A | 419 King Street
Newtown NSW 2042
P | 02 9168 9893
E | admin@wmseng.com.au
W | wmseng.com.au
ABN | 85 700 247 836
Ref | 20345-L01-2
Date | 16 January 2026

24-28 Middle Harbour Road, Lindfield – Response to NSW SES Feedback

The Proponent has received feedback from the NSW State Emergency Service (SES) following the submission of the Flood Impact and Risk Assessment (FIRA) as part of the EIS submission for the SSD (SSD-82548708). The responses are identified below and references are provided to show where they are addressed in the updated report.

Post-Development
Peak Flood Hazard Afflux
PMF

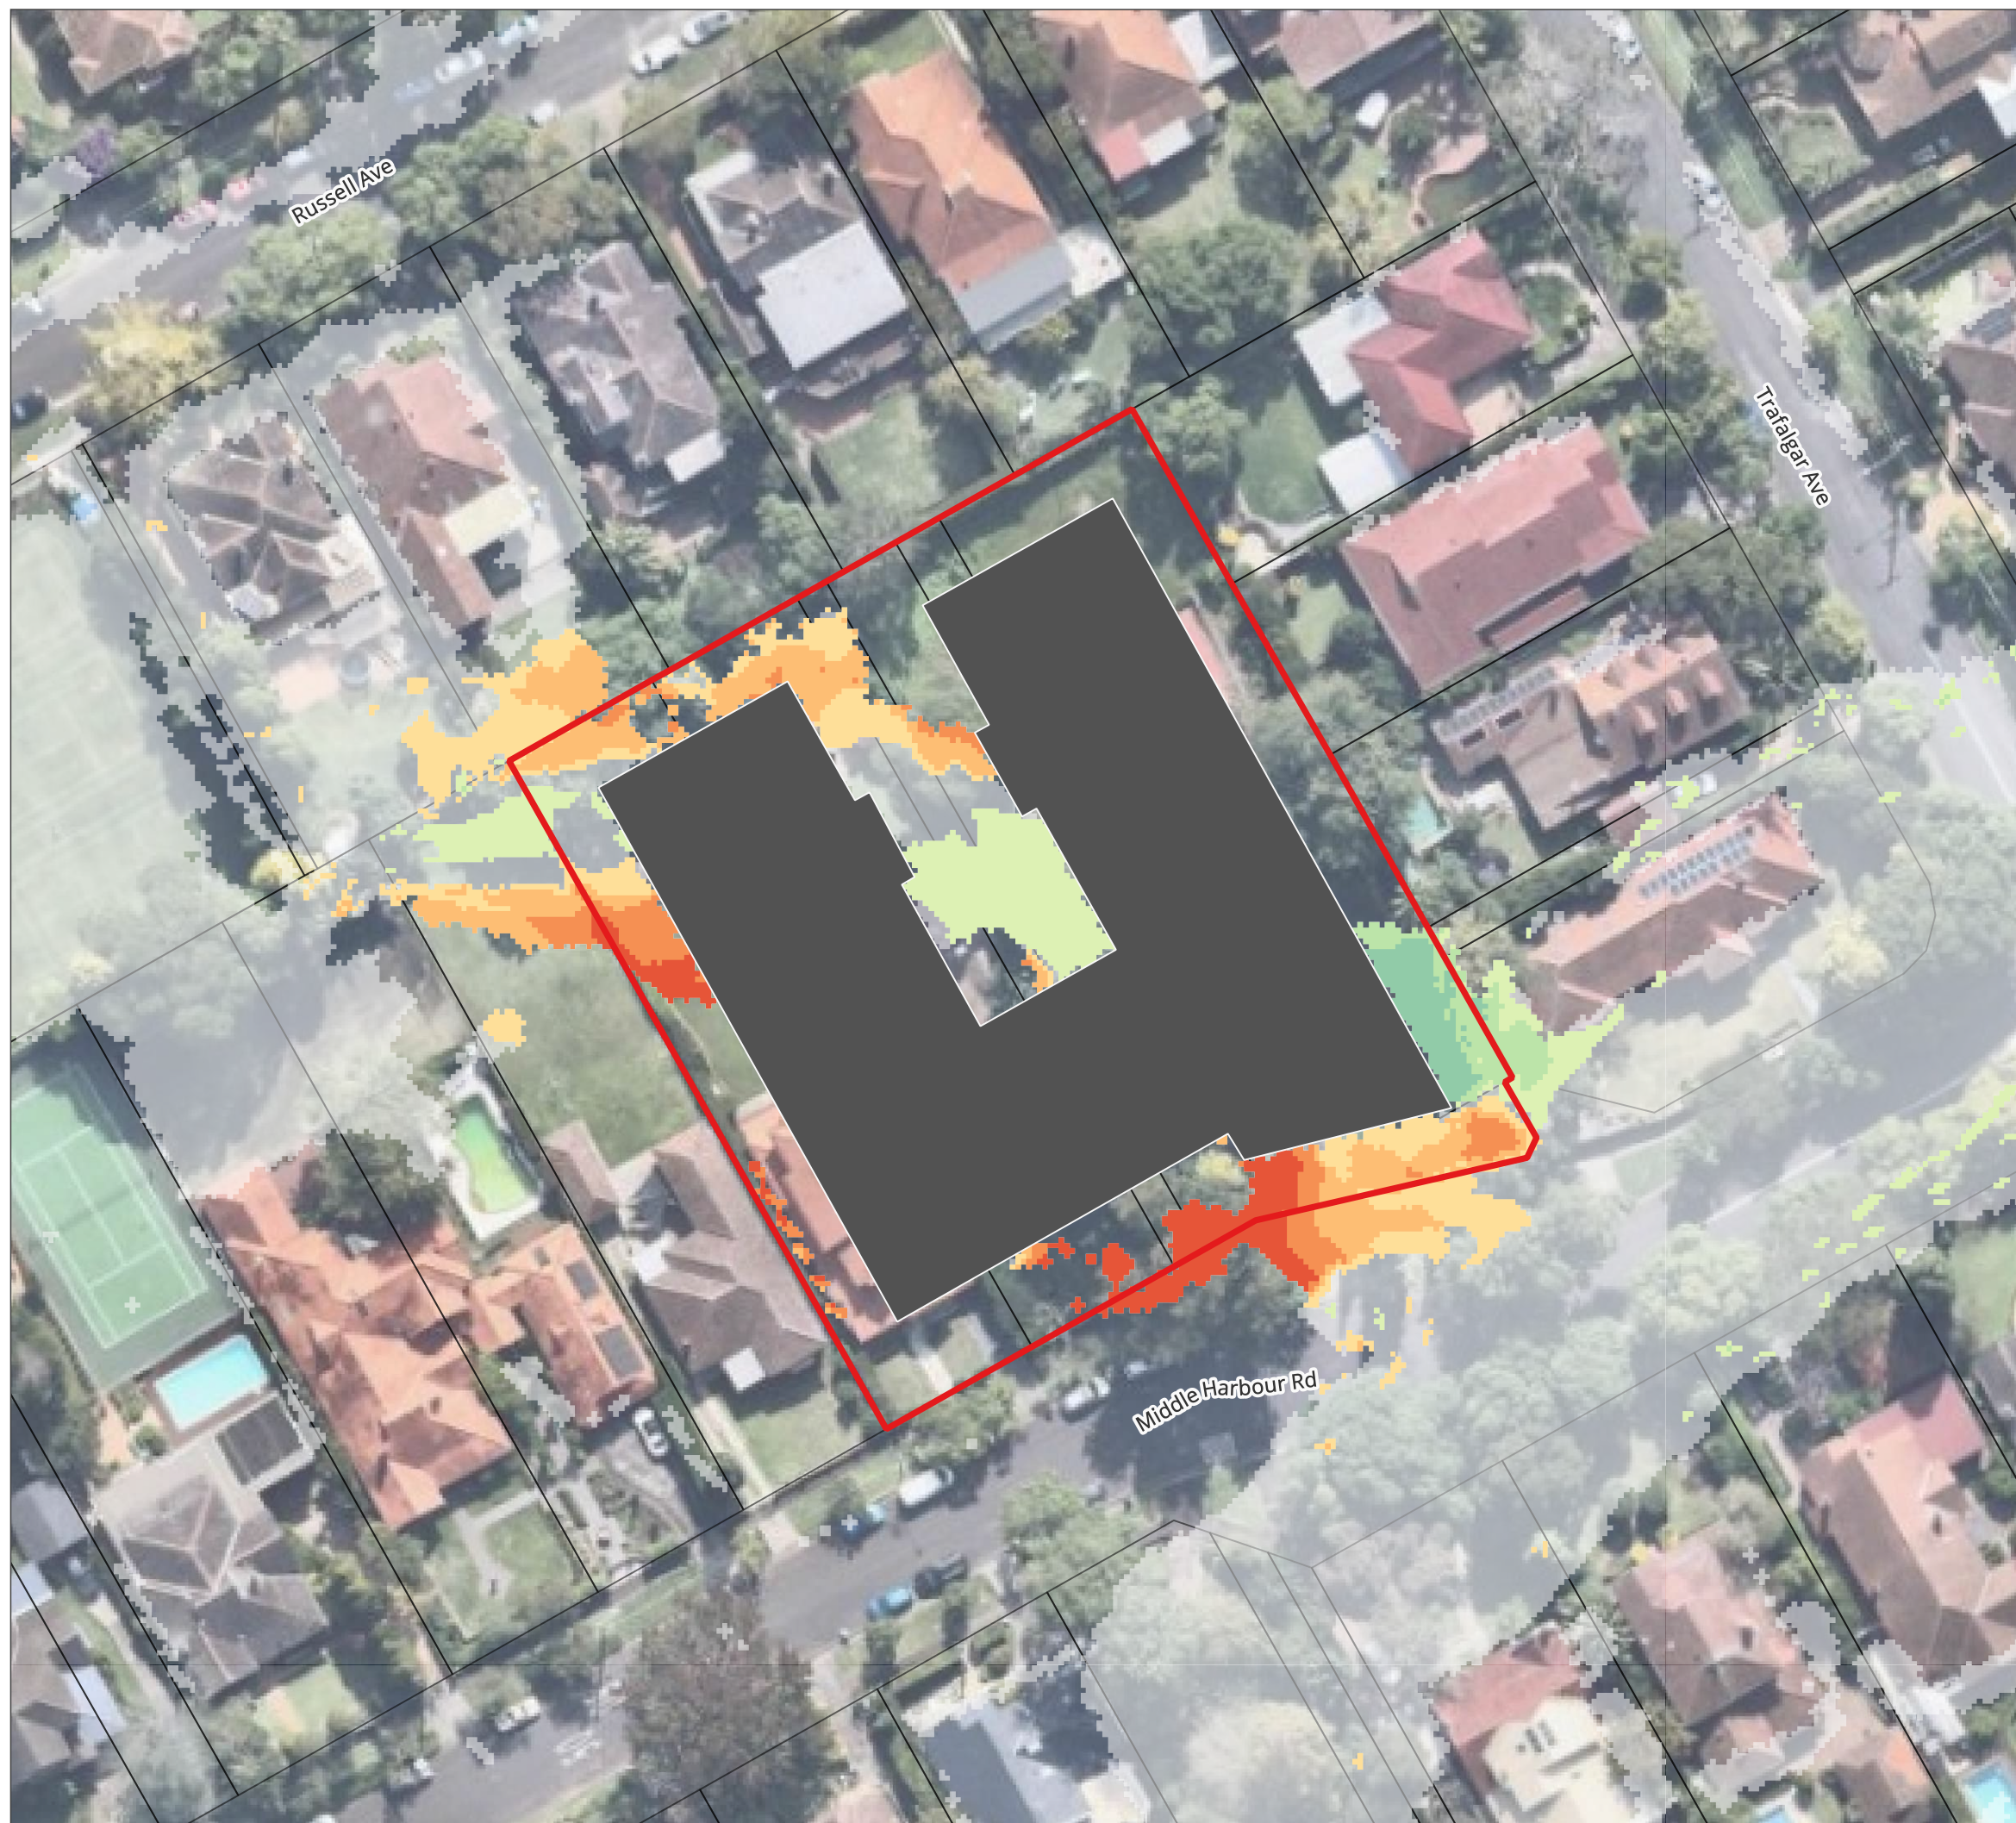
During the PMF the site currently becomes inundated to depths of up to 1 metre, but under post-development conditions becomes inundated to depths of up to and greater than 2 metres. The afflux maps also indicate that the proposed development would increase flooding on adjacent sites to the north, west and south of the site during the PMF by up to and greater than 0.3m, and would introduce floodwater to properties and parts of properties that would otherwise have been dry. This proposal would therefore impact on the existing community, and we recommend removing the statement “the proposed development results in limited flood level afflux within neighbouring properties” as this does not hold true for all events up to the PMF.

It is acknowledged that in the PMF event there is increase in flood levels on adjacent sites to the north, west and south. However, in the north and west, the increase is contained to the rear of the adjacent properties and therefore does not result in a worsening of evacuation ability of these properties, which can still evacuate through their frontage to Russel Avenue or Middle Harbour Road. The increases in flood levels in the south of the site are contained within the road reserve, which under pre-development conditions is already subject to inundation and therefore would not serve as an evacuation route.
